From: Ian Brewster
Sent: 02 July 2013 18:32
To: Anita Gardner
Subject: RE: EP/111/12 45 The Ridings and 60-62 Sea Lane East Preston BN16 2TW

From: Ian Brewster
Sent: 02 July 2013 18:26
To: Anita Gardner
Subject: EP/111/12 45 The Ridings and 60-62 Sea Lane East Preston BN16 2TW

FLOOR PLANS & ELEVATIONS
UNIT 2

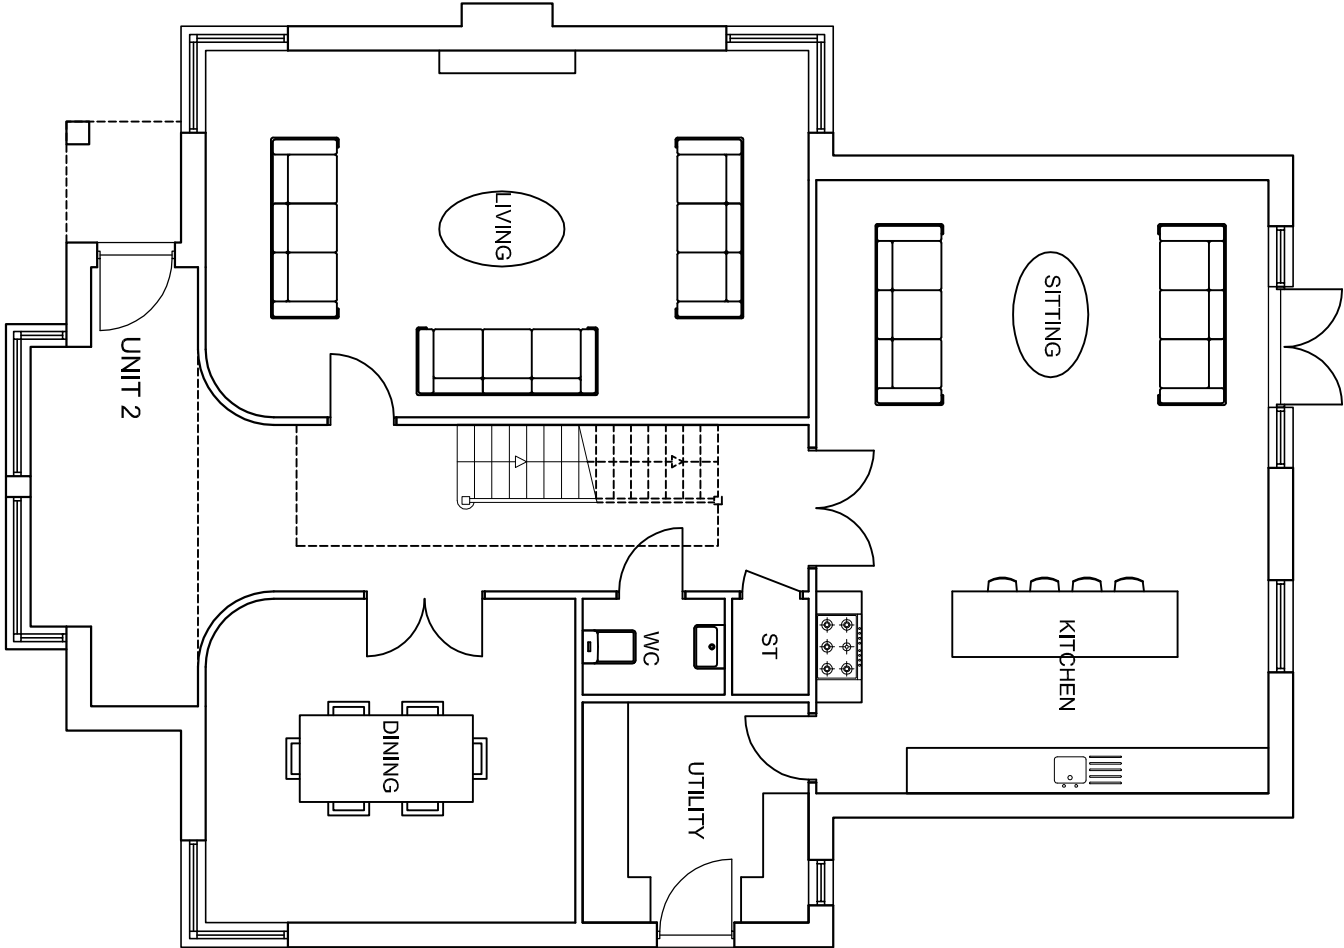
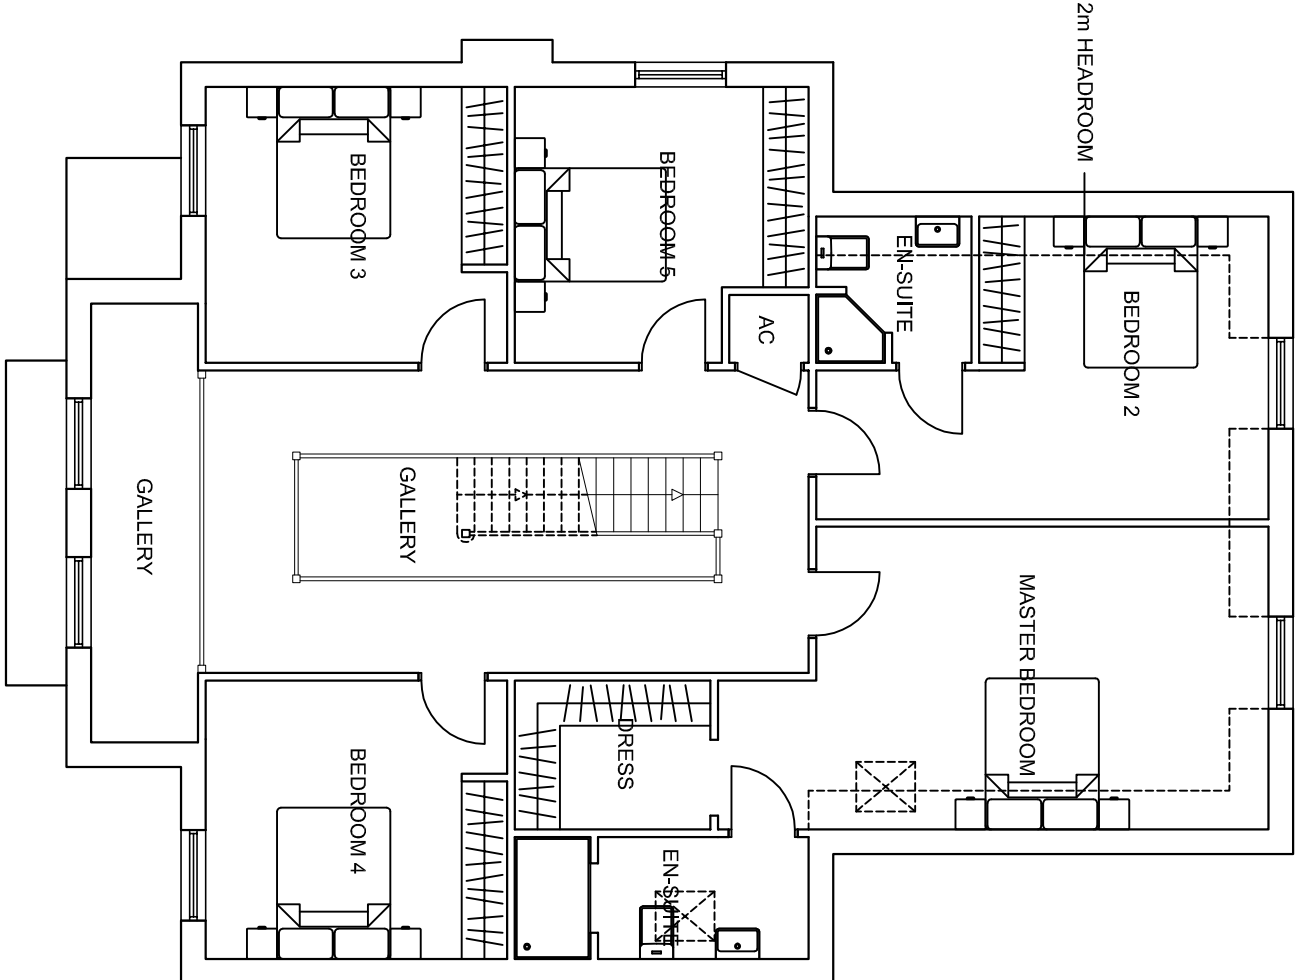
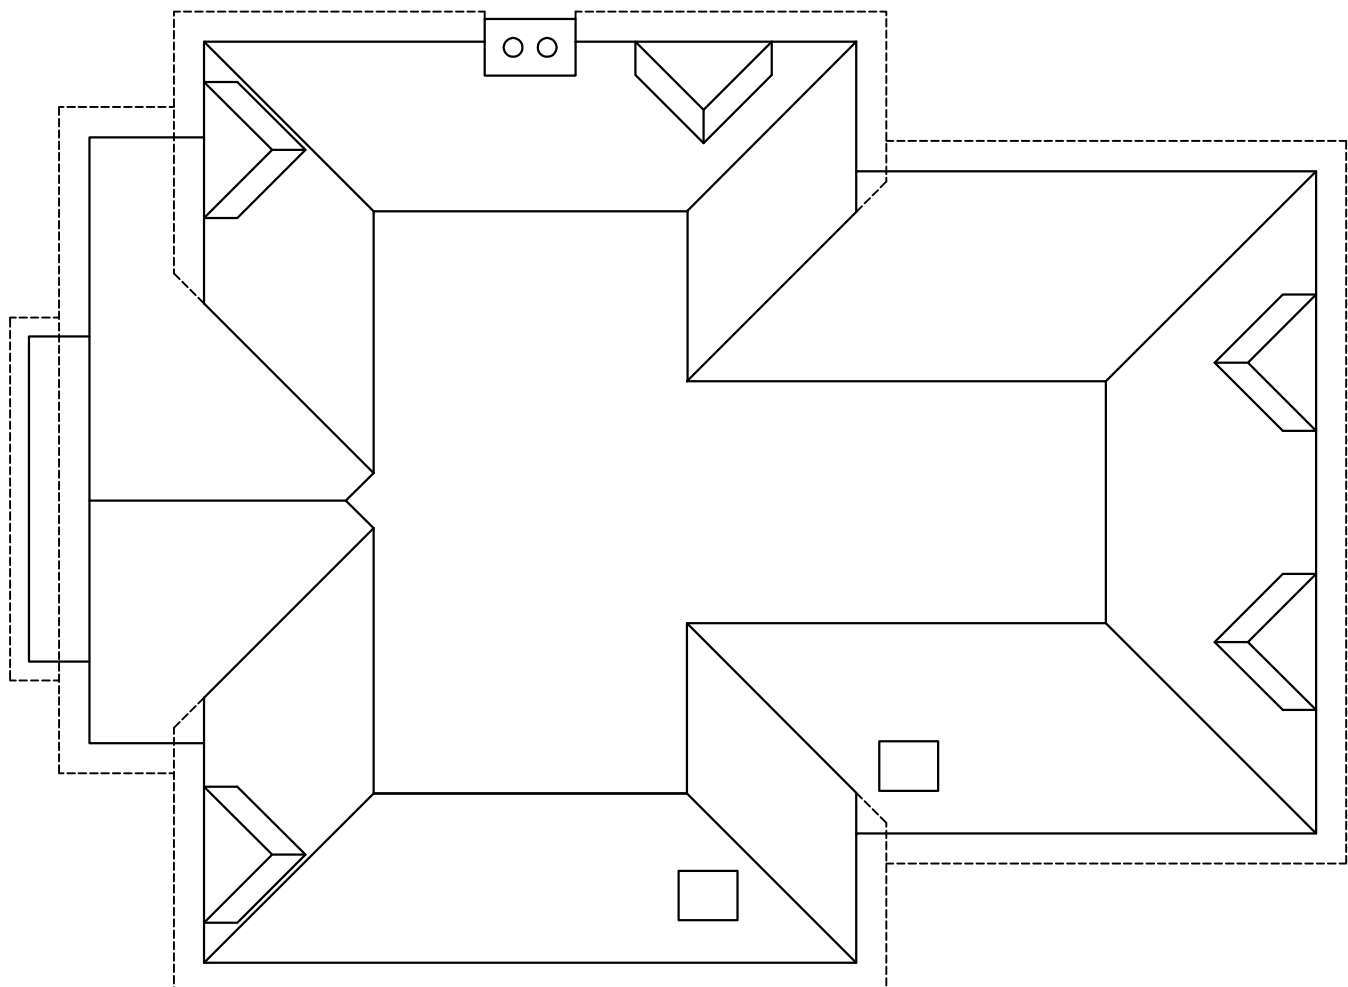
The above proposal will affect two 'B' category Hawthorn which grow within the garden of No. 64 Sea Lane. The building of the proposed driveway and garage of Unit 2 will require the severe cutting back of overhanging branches to allow unobstructed access to the garage. The garage foundations will damage roots of the Hawthorn. The design needs to be sympathetic towards the retention of these high grade trees otherwise they will be destroyed.

SITE, BLOCK & LOCATION PLAN

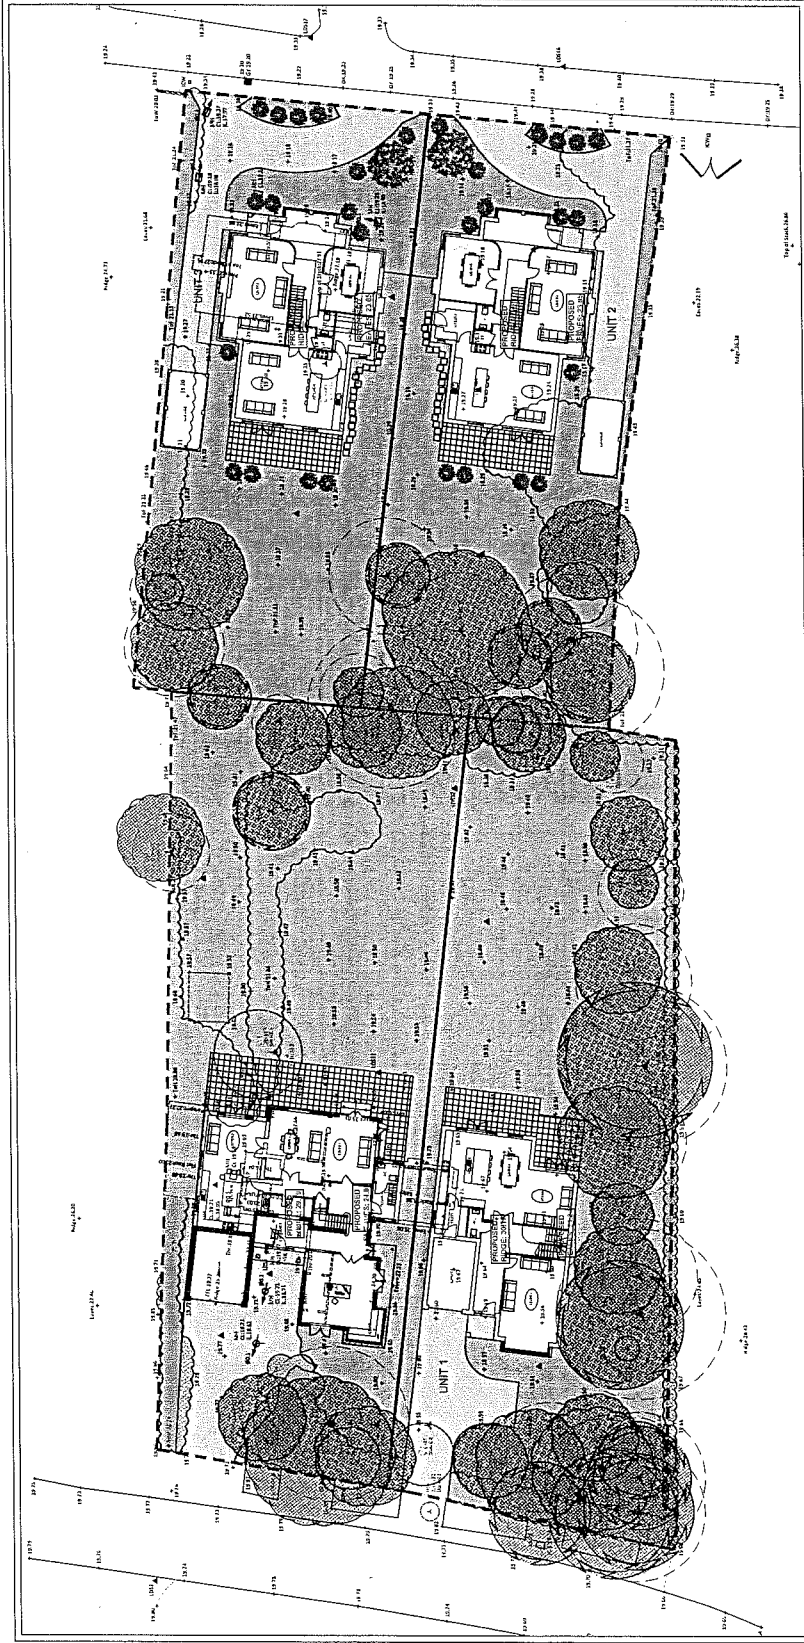
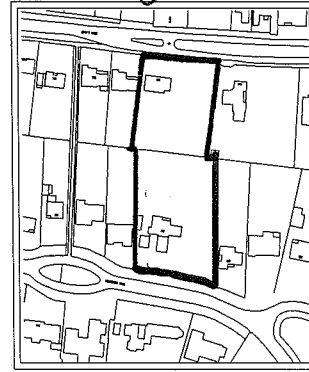
I should have added that further to my previous message both trees do provide a screen between the new development and existing property.
